Recommendation Report for Works to Tree(s) on trees subject to a Tree Preservation Order (TPO)

REF NO: AW/84/18/T

LOCATION: 33 Grange Court
Aldwick
PO21 4XR

PROPOSAL: Re-Pollard 1 No. Golden Weeping Willow Tree by 3m, back to previous points.

T1

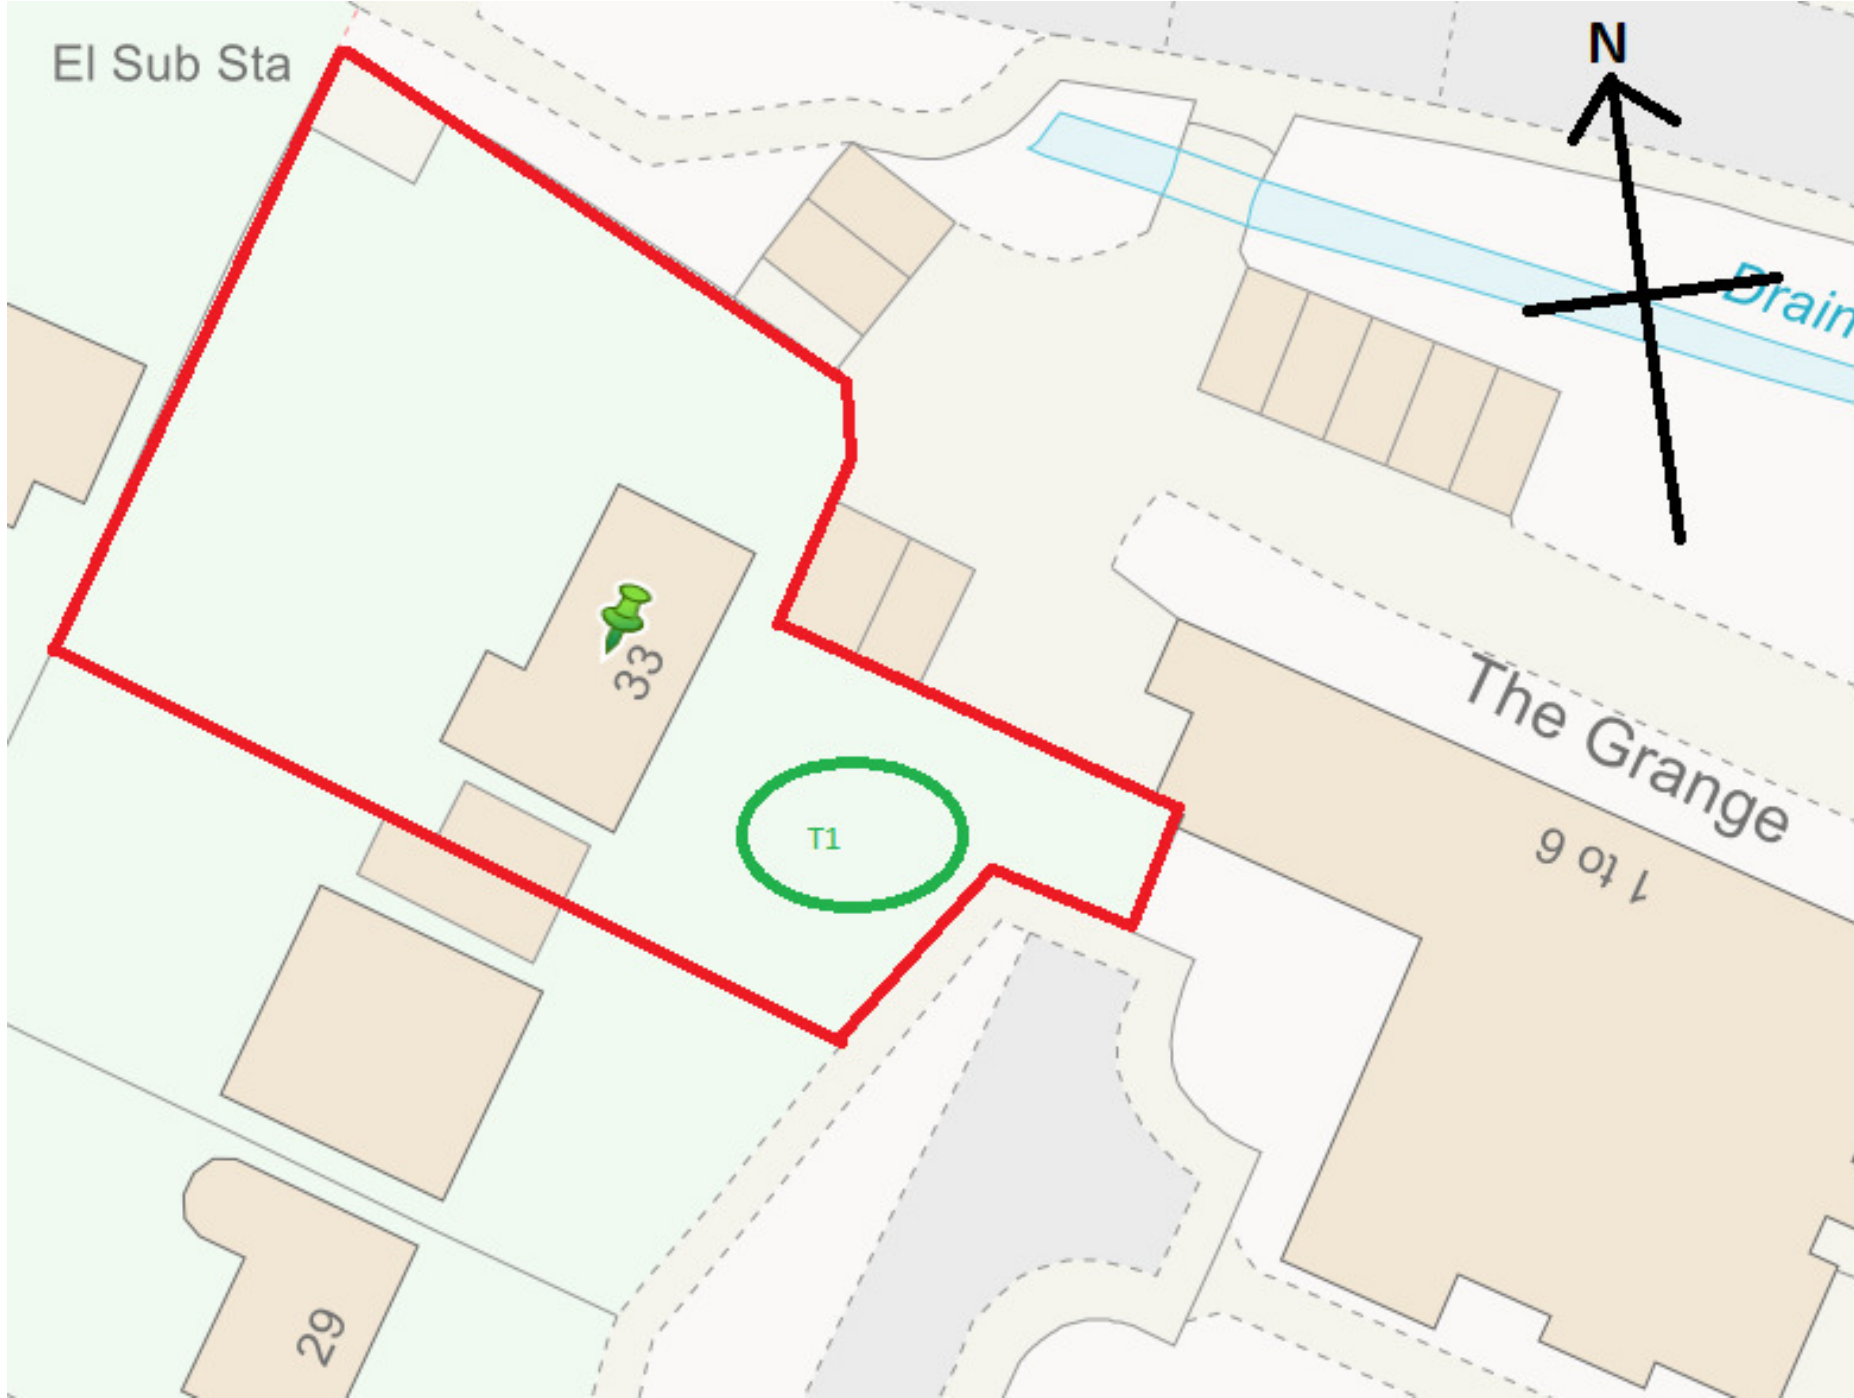
Tree Officer -
Golden weeping willow - *Salix x sepulcralis* var *Chrysocoma* - Height: Approx.10m - Average spread: 5m
- Age: Early-mature

- This tree appears to be in good physiological condition. It has been subject to heavy crown reduction work previously and has responded with vigour; typical for a healthy example of its type and age.

- This tree is visible from surrounding properties and occupies a prominent central position to the front of this property.

- Repeat operations such as now being asked for by the applicant will be necessary throughout the remaining life-span of this tree, to achieve a reasonable degree of structural integrity appropriate for its location.

- If the work is undertaken to a good standard and at the right time; then repeat crown reduction is unlikely to have an adverse effect on its long-term vitality.

- The long-term vitality of this tree is best respected when significant pruning work such as proposed, is undertaken during either the mid-summer (mid-June to mid-September) or mid-winter (mid-December to mid-February) periods.

Condition - The removal of crown material which has developed since the last operation must be done sympathetically and with respect to established 'knuckles' so as not to extend beyond the point of origin.
